## MEMORANDUM

Date: November 4, 2013  
To: Virginia Fox  
From: Matthew J. Miller, P.E.  
Re: Porch Rafter Review

TYPICAL - NOT TO SCALE

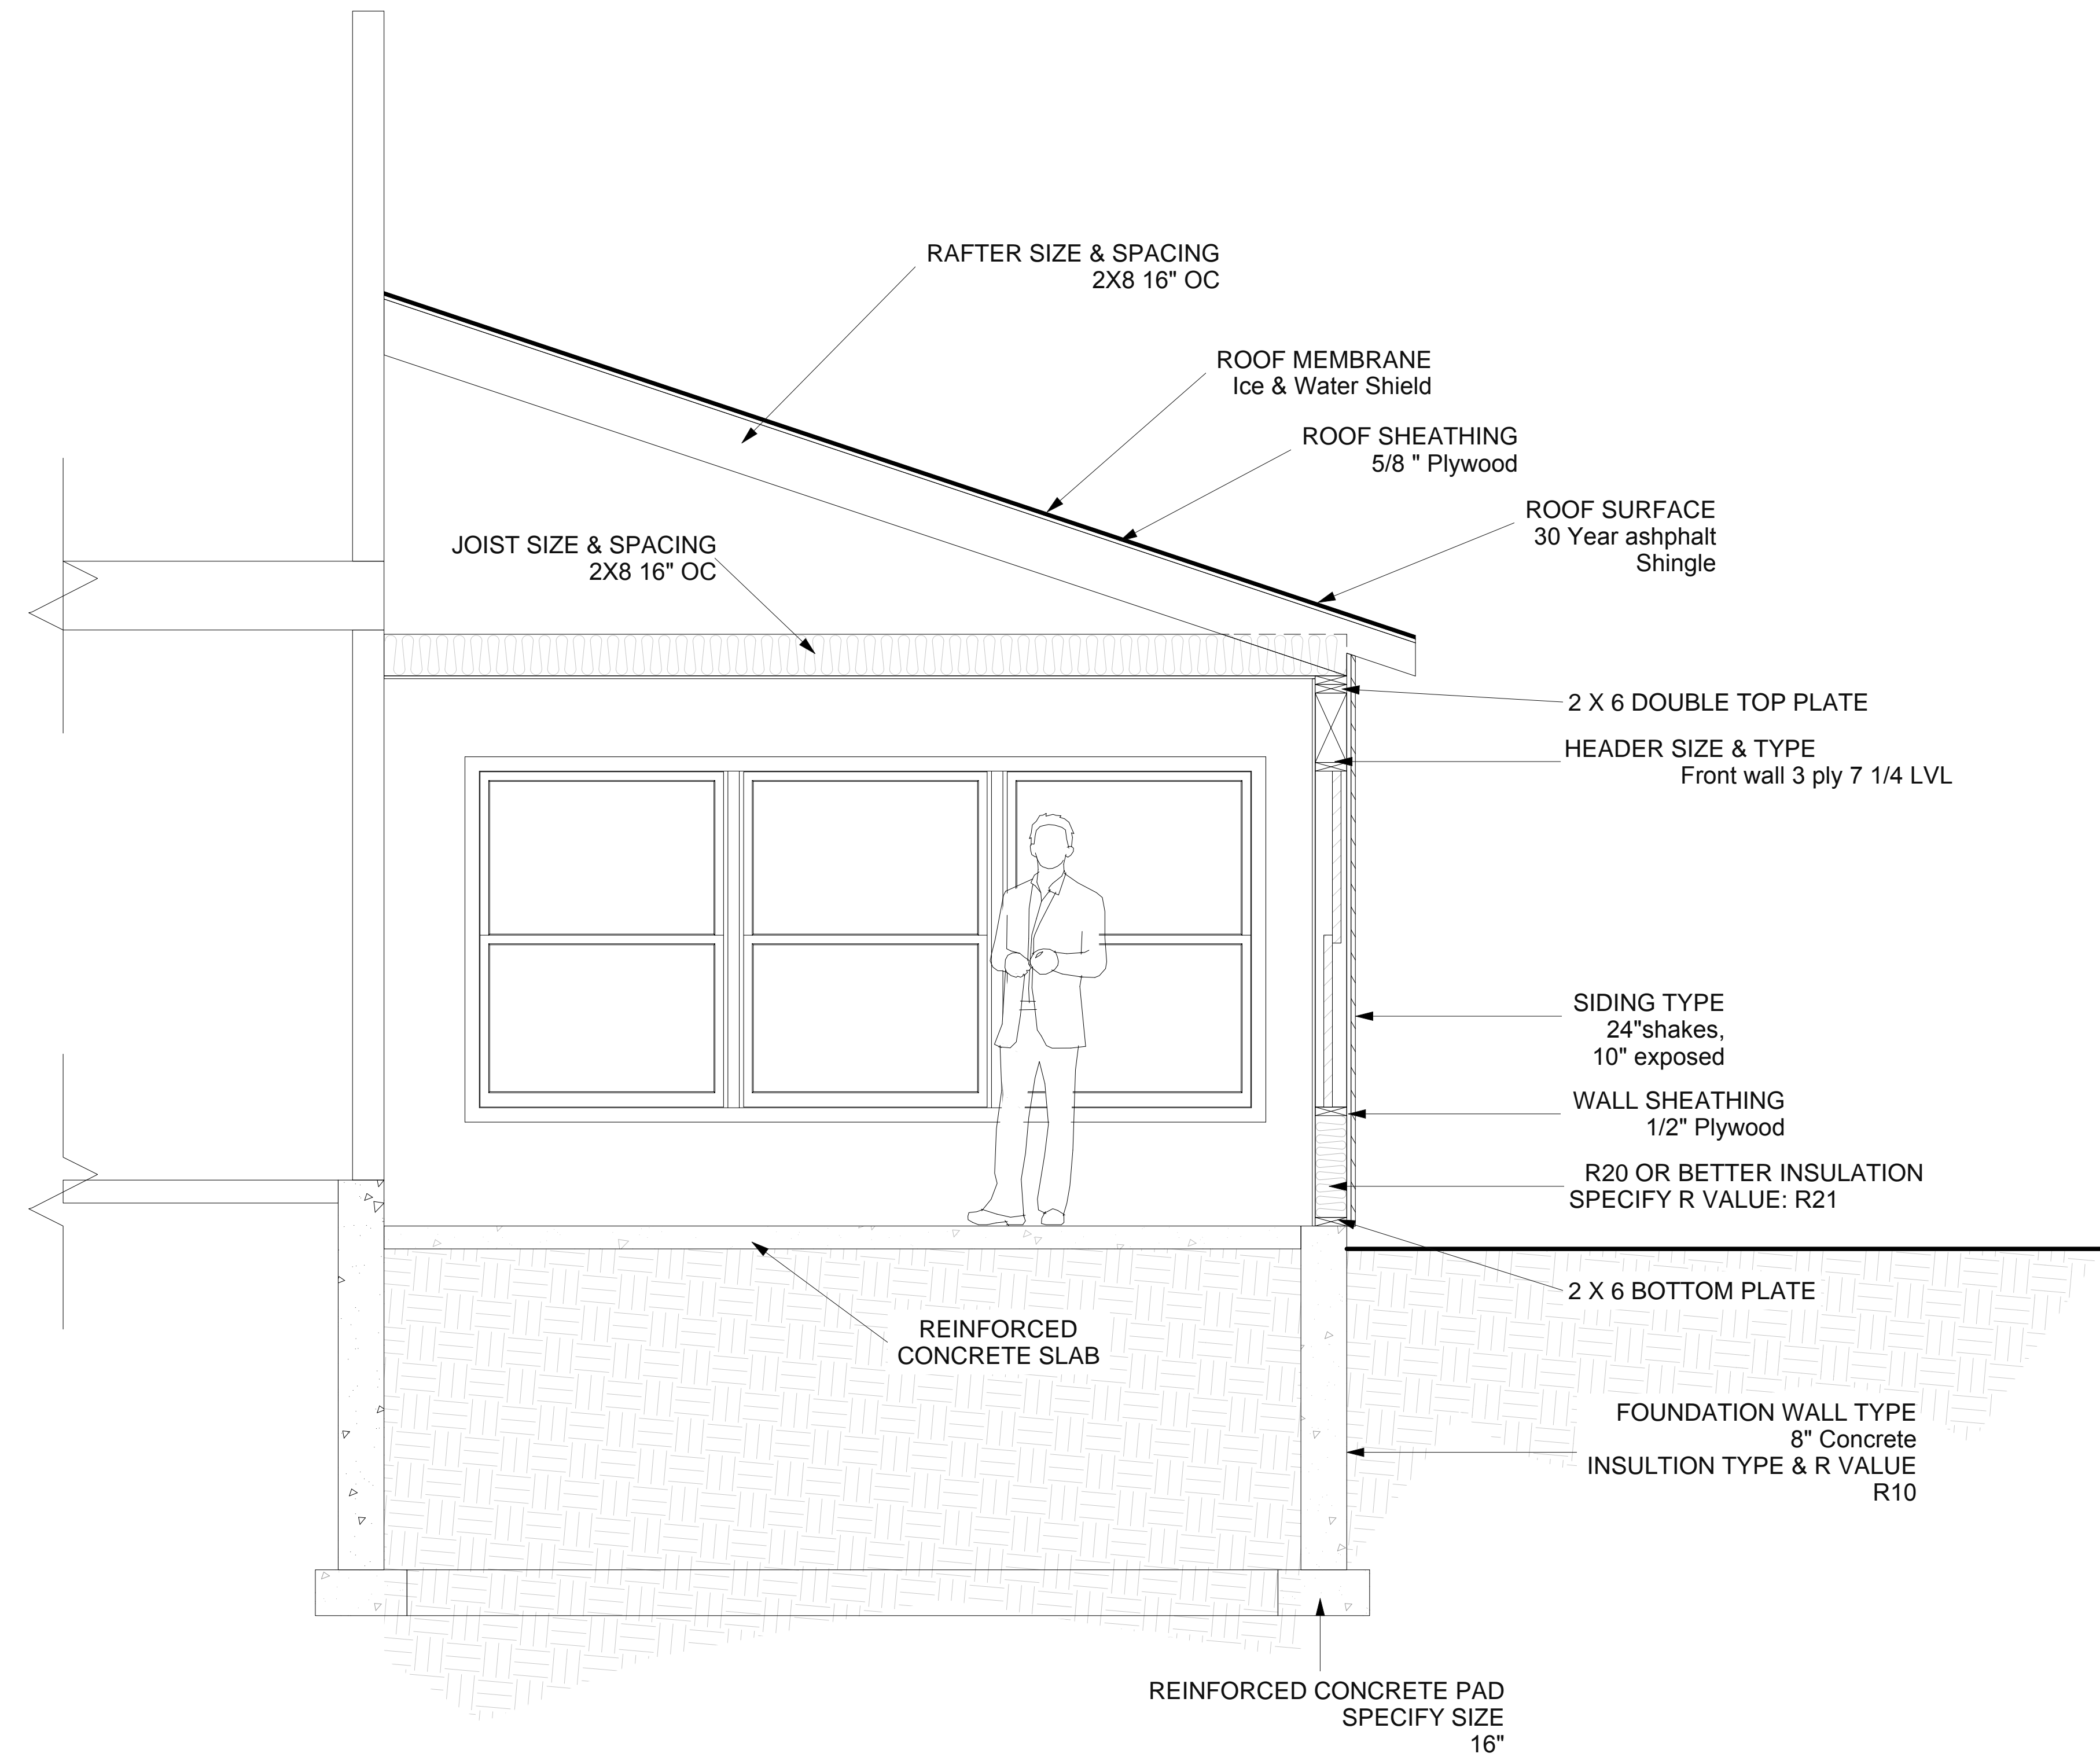
We understand that the roof over the addition to your house was constructed with 2x8 rafters spaced at 16" on center with a clear span of 13'-6", which exceeds the allowable span of 12'-4" for Spruce-Pine-Fir No. 2 rafters in accordance with the International Residential Code.

In order to support the code required snow loads based on a ground snow load, Pg, of 50 pounds per square foot and the potential drifting snow from the adjacent roof we recommend sistering an additional full length 2x8 to the existing rafters. The new rafters shall be fastened to the existing rafter with (2) rows of 10d nails at 16" oc.

In addition to the addition of new roof rafters, we recommend that the connection of the ledger board to the wall studs be reviewed to ensure that it is adequate. At a minimum, three (3) 3-5/8" long Fastenmaster LedgerLok or Timberlok Screws should be installed at ea. stud location.

With the additional 2x8 installed the allowable load capacity of the rafters will exceed the required design loads.
